File No: SF17/52552
Ref No: DOC17/560755

**RE: REVIEW OF ENVIRONMENTAL IMPACT STATEMENT FOR INLAND RAIL -
NARRABRI TO NORTH STAR (SSI 7474)**

The Heritage Division, as delegate of the Heritage Council of NSW, has reviewed the following EIS documentation:

Figure 7.7 Moree Station track realignment

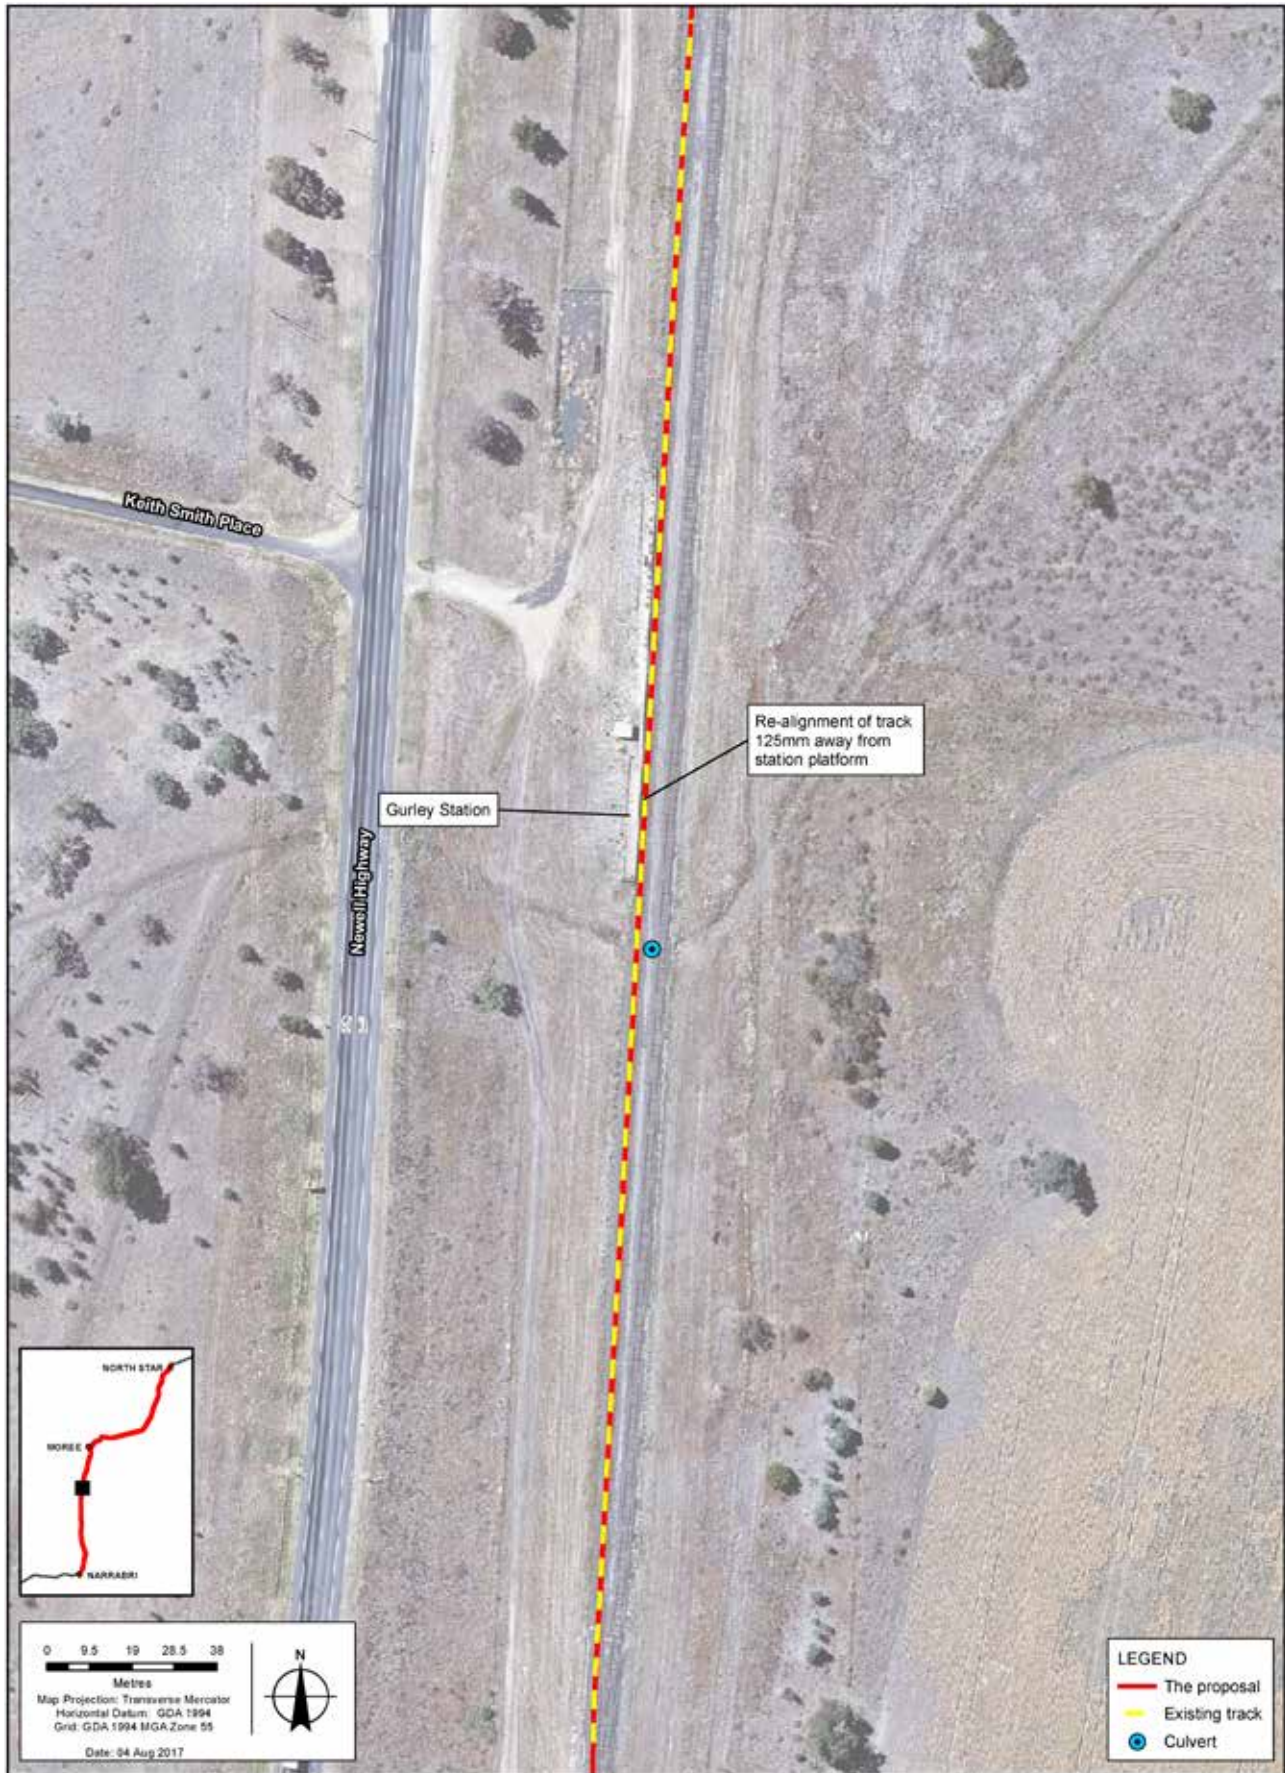
The proposed works through Moree Railway Station will follow the existing alignment and includes a track slew of 125 millimetres to enable clearance from the existing station platform. This will require a change in the boarding platform used by the Sydney Trains. However, no heritage features will be directly impacted by the proposal. As the railway station is located immediately adjacent to the proposal site there is potential for construction and operational vibration impacts.

- Any new bridge structures constructed should incorporate design elements from the existing steel truss bridge design to mitigate visual impact.
- Heritage elements within the Moree Railway Station must be protected during construction works.

Figure 7.14 Mehi River bridge

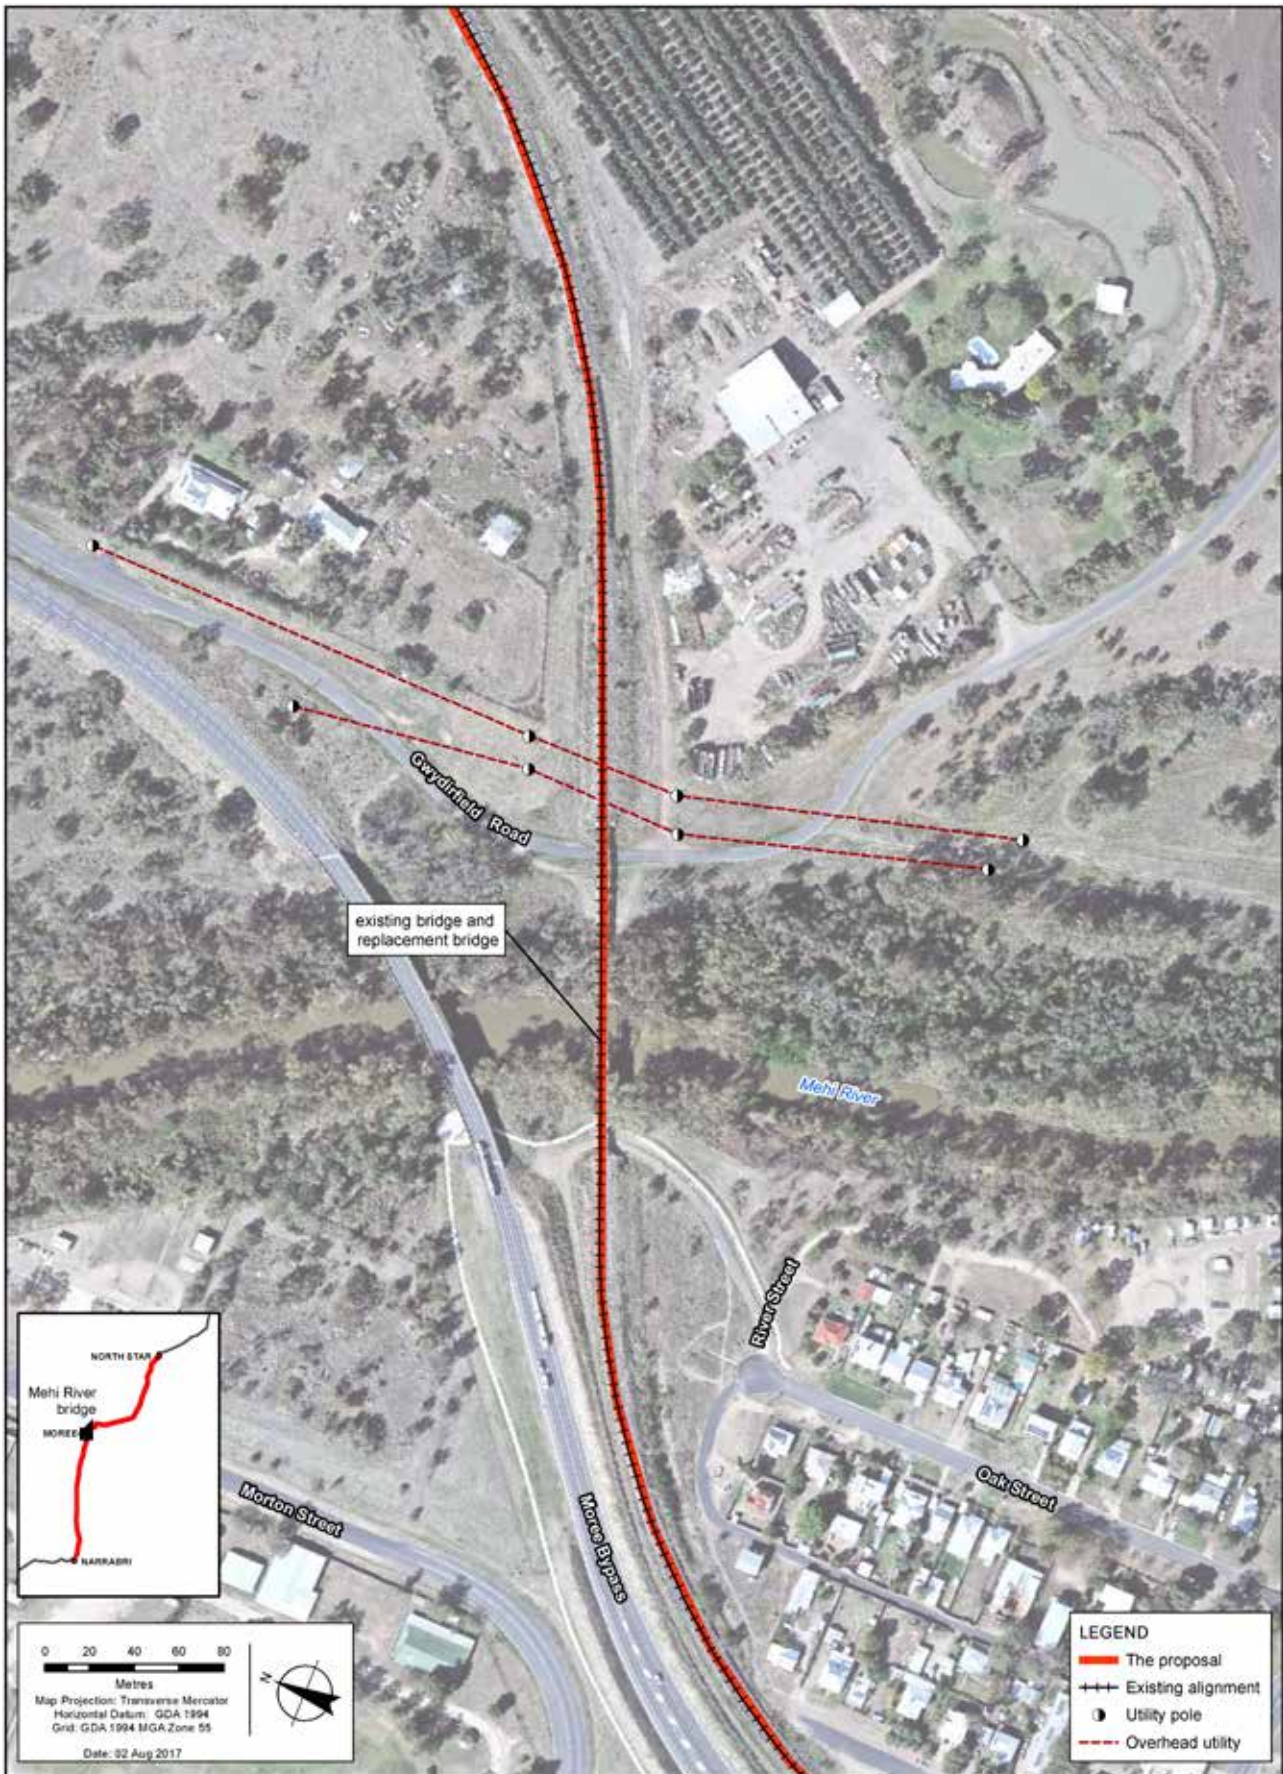
- The demolition of the Mehi River Underbridge at Moree is not supported. The underbridge is a visible landmark from the Moree Bypass (A39) and should be retained as an example of a steel Pratt truss bridge constructed on the Pioneer Line using American Bridge Technology. The bridge should either be strengthened or duplicated. If the bridge is to be duplicated, the new structure should be located to the east of the existing bridge to retain sightlines from the A39.

Figure 7.15 Gwydir River bridge

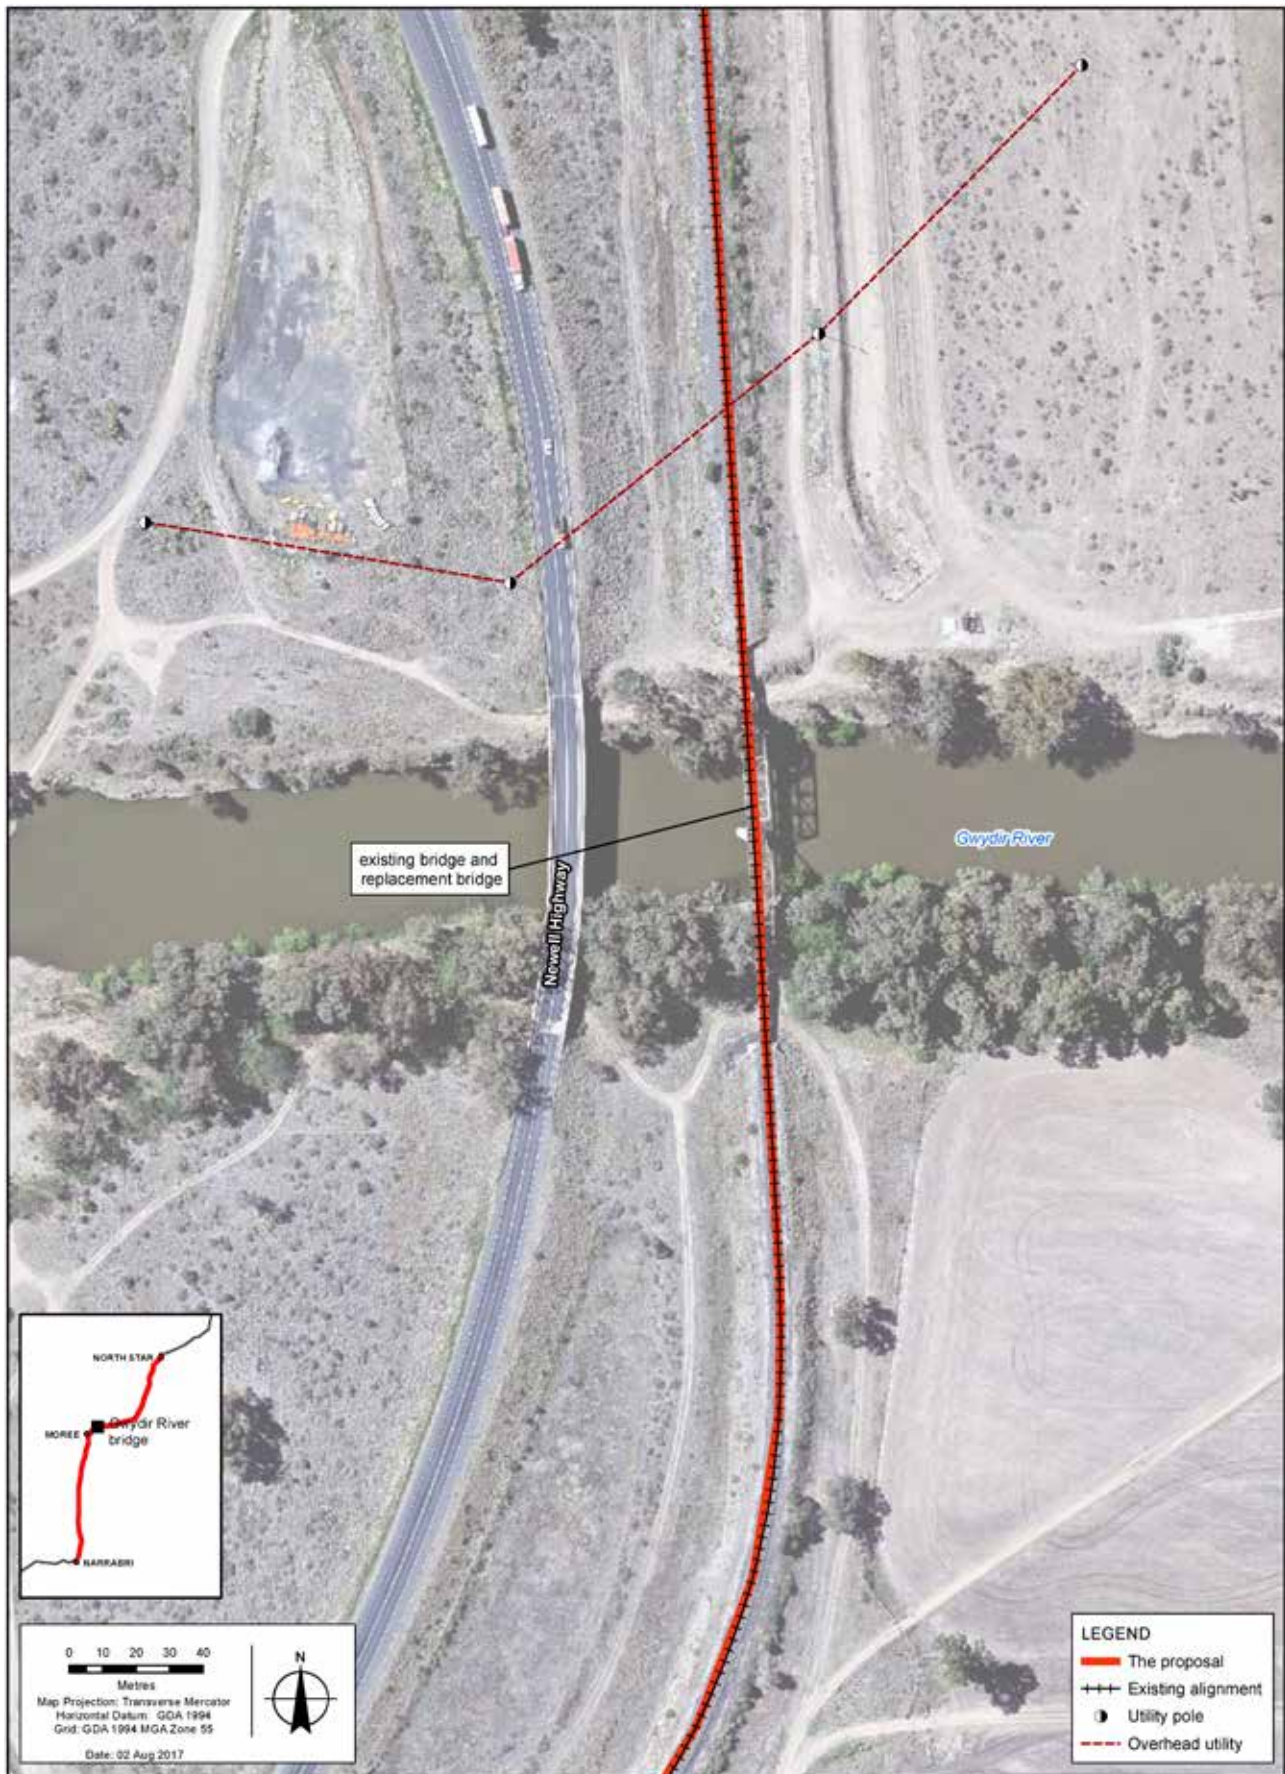
The option of upgrading these bridges or building new bridges next to them was considered in the EIS, but discounted due to ongoing maintenance requirements and safety issues. It is the Heritage Council's preference for the rail bridges to be retained and strengthened rather than demolished.

The main justification for demolition presented in the EIS is that there are numerous examples of the steel Pratt truss bridge type within NSW (The 2011 ARTC Section 170 Heritage and Conservation Register lists over 20 steel truss underbridges). However, it is our view that these bridge examples are part of a decreasing resource across NSW and the cumulative impact of the proposed loss of another three examples of this type poses a heritage risk.
